KNECHT SUBDIVISION

A PORTION OF THE NORTHWEST QUARTER OF SECTION 18,
TOWNSHIP 12 SOUTH, RANGE 64 WEST OF THE 6TH P.M.,
EL PASO COUNTY, COLORADO

DSD FILE NO.: SF2419

FINAL PLAT
KNECHT SUBDIVISION

FINAL PLAT  
**KNECHT SUBDIVISION**

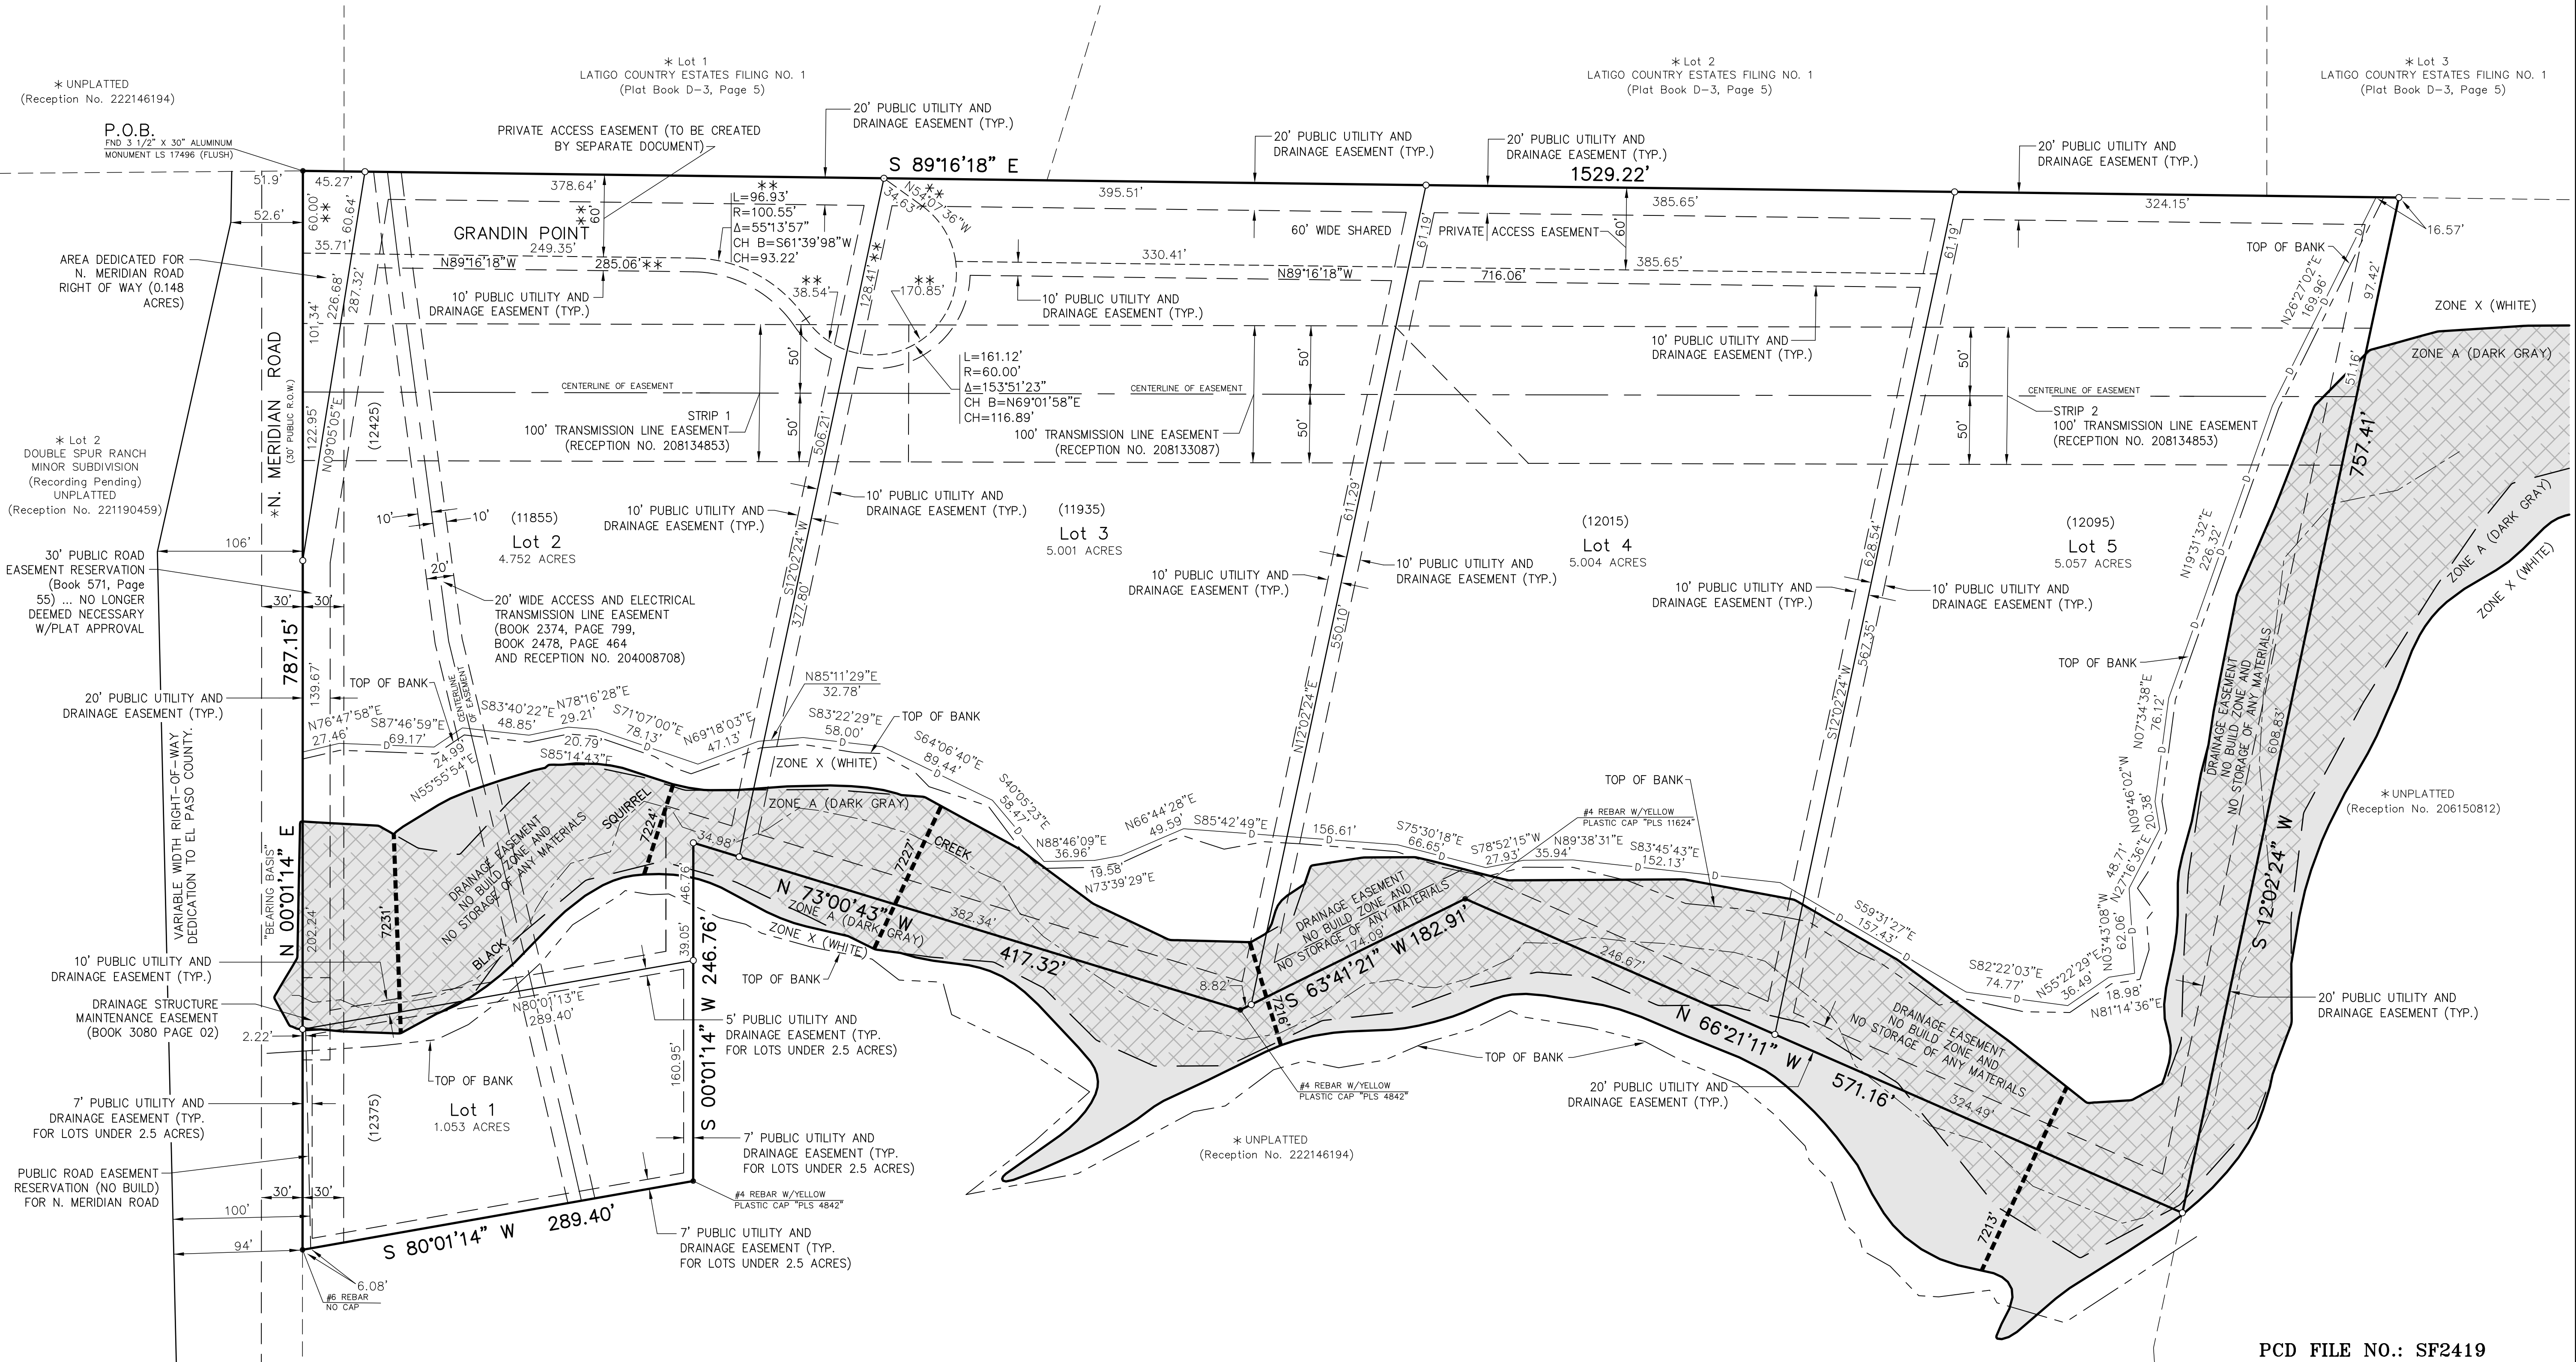
Meridian Road is a Minor Arterial with 100' of ROW required. Please provide for ROW dedication for 50' from the roadway centerline.

New private road easement will need to vacate this easement. Can't have two overlapping easements.

Indicate the width of the private road in the label and update the label to identify it as a road, not a driveway

What is the purpose of this easement if 20 ft is provided on the north side of the private road?

The driveway location on the drainage report is shown outside the easement. Please adjust private access easement so the driveway for lot 5 is included.

Per Engineering comment, this should be a 50 ft dedication, not a 30 ft reservation. Easement width will begin on the east side of the land dedication.

Can this part encroach into the transmission line easement?

This lot is not large enough, and will be even smaller after the right-of-way dedication. You may have 4.75 acres for the lot adjacent to Meridian Road, but all other lots must be greater than 5 acres. Right-of-way dedication shall be excluded from lot area measurements.
